## Application for a Non-Material Amendment Following a Grant of Planning Permission

Land East of Camp Road & North of Hannah Crescent Phase 2a, 3a & 3b

Application for approval of reserved matters for 181 dwellings (cells 2a, 3a and 3b) comprising details of appearance, landscaping, layout and scale pursuant to outline planning permission 15/1347/OUT

21/0276/RESM

title: **Planning Layout**

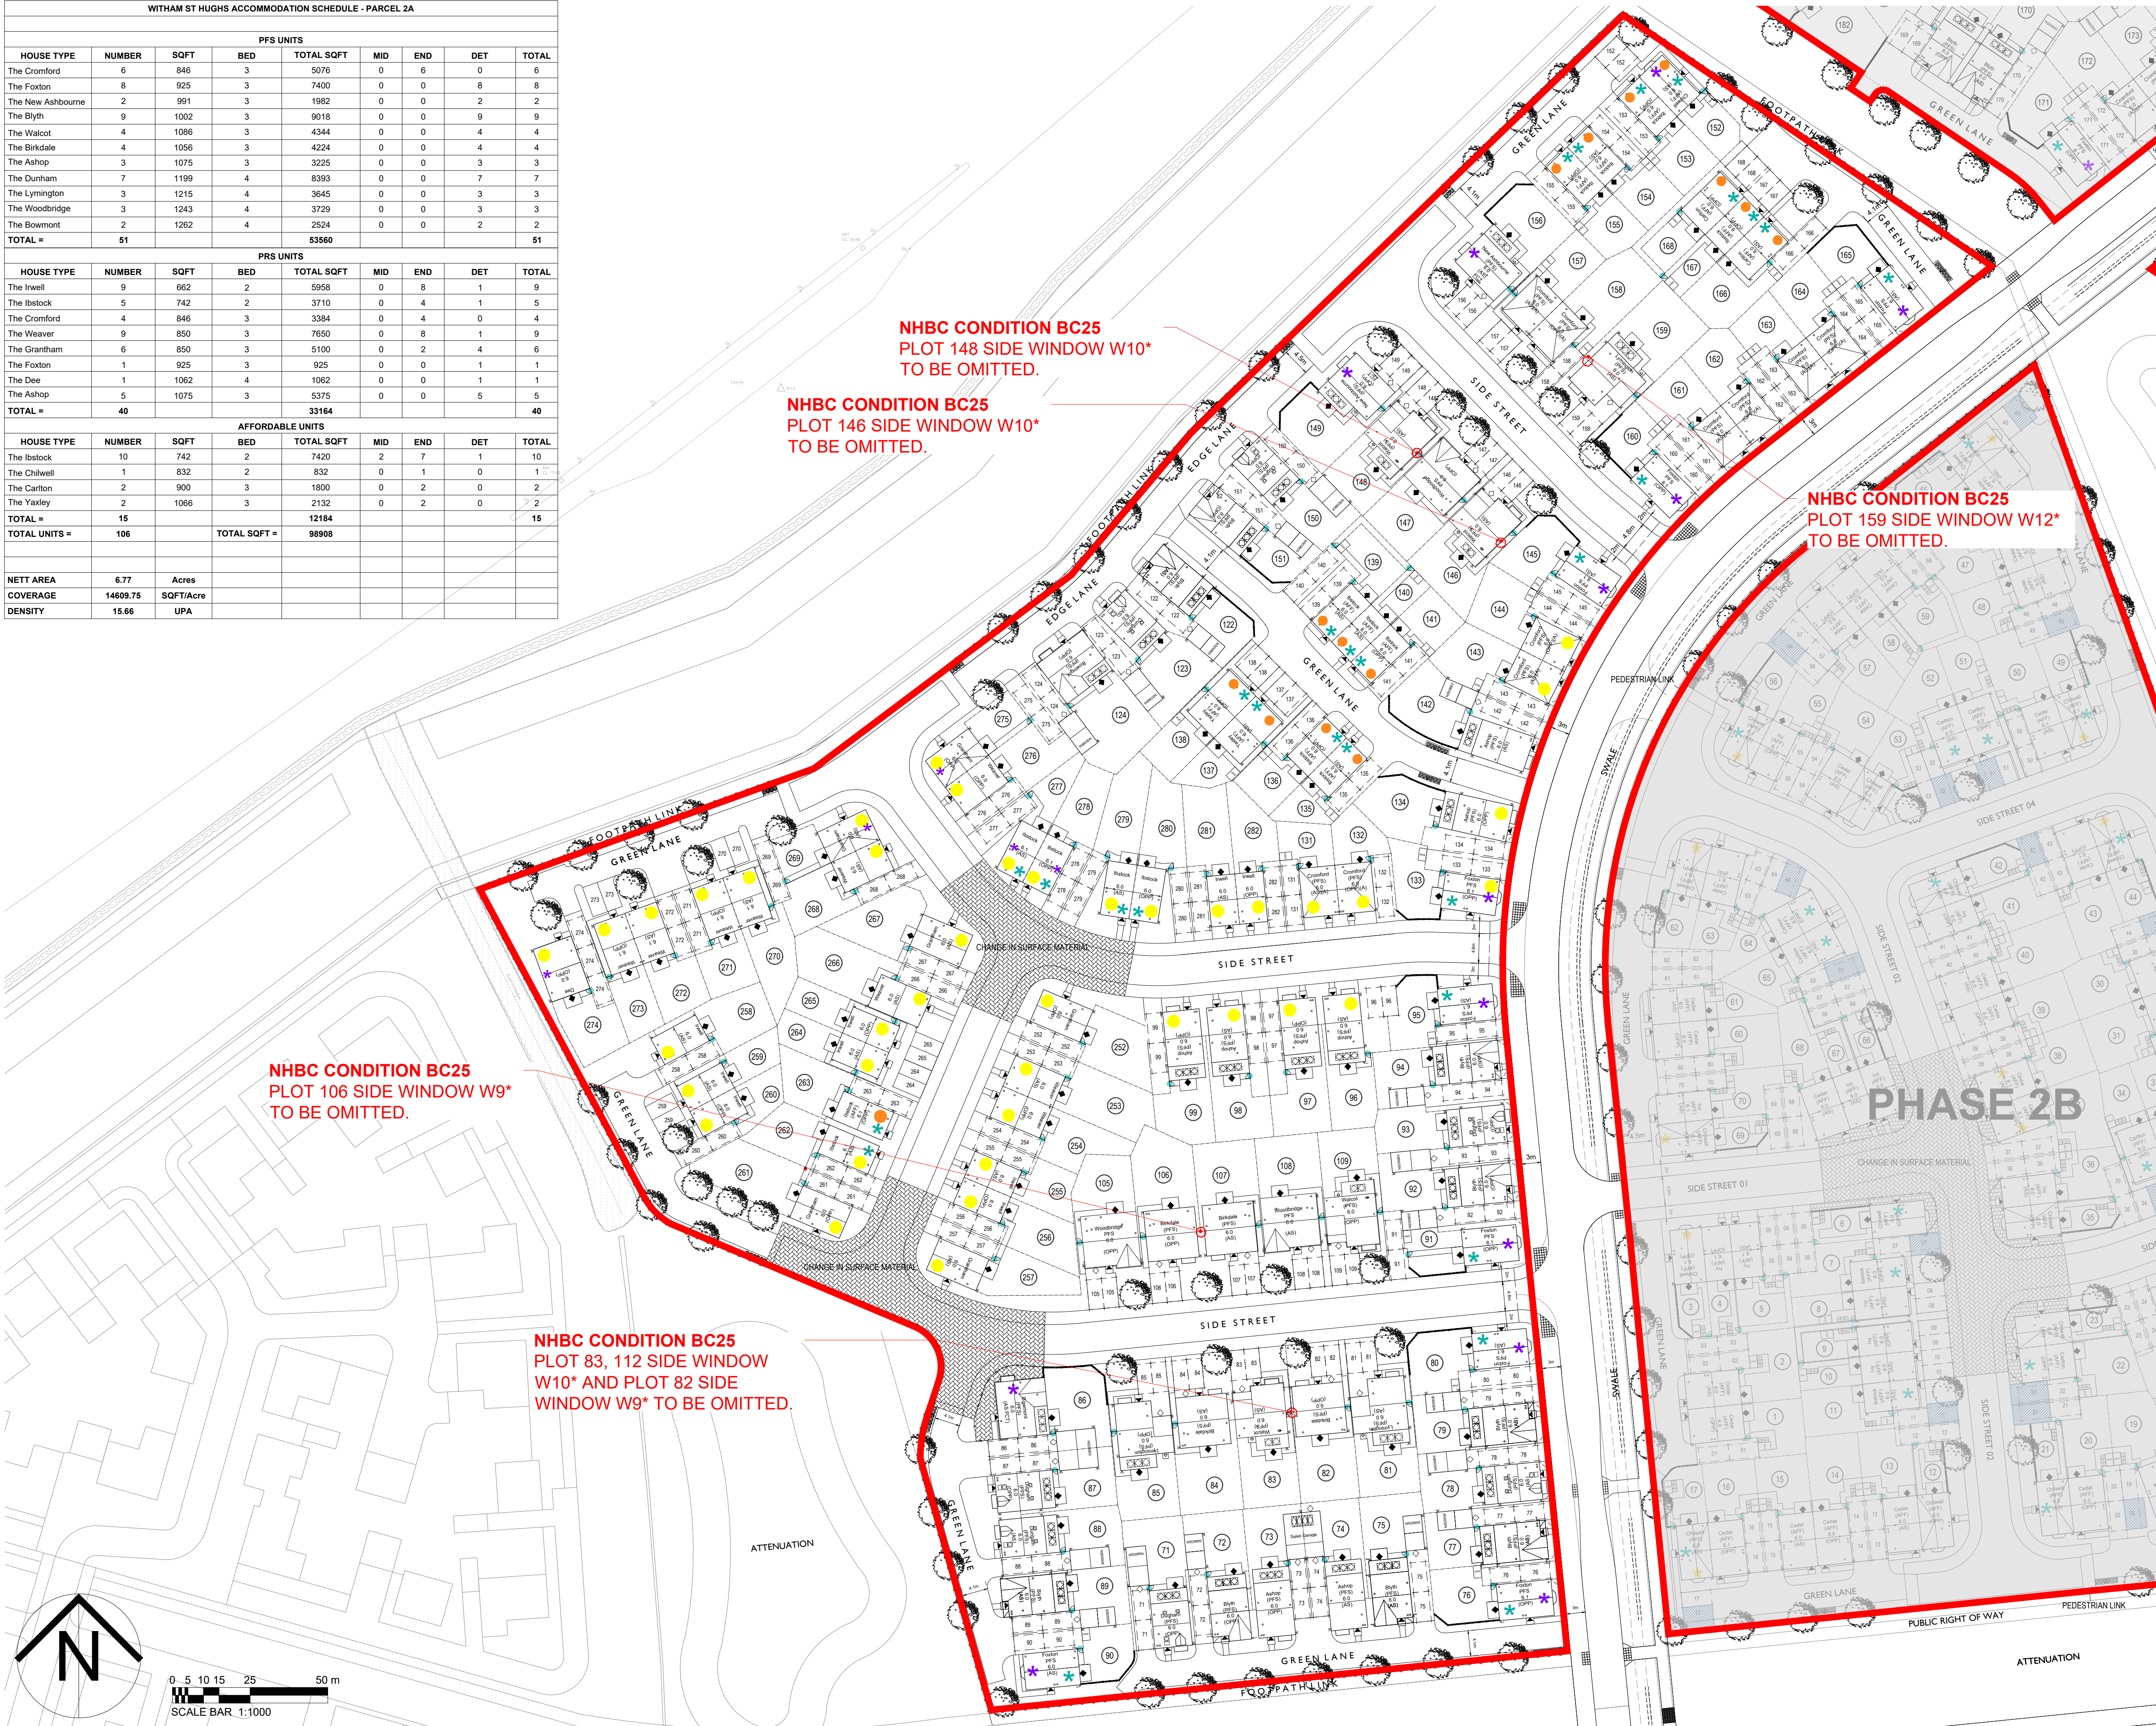
1. Amendments to the approved plans to remove trip rails to the boundary of the development parcels
2. Amendment to the wording of condition 3 of the RM approval 21/0276/RESM to add: "The boundary treatments approved shall thereafter be retained in perpetuity for the duration of the development."
3. Addition of bin collection points to Edge Lanes which are to remain private and will not be adopted. BCPs added opposite plots 184,191, 149

The main issue appears to be how waste collections would be undertaken as the Council's refuse vehicles will not normally enter private drives without a signed waiver in place, and the scheme as approved does not provide BCPs adjacent the adopted highway limits. Further, the status of the edge lanes is set out on the attached plan which forms part of the approved plans for the development. The change to private drives (or to not construct to adoptable standard) would therefore not be in compliance with the permission.
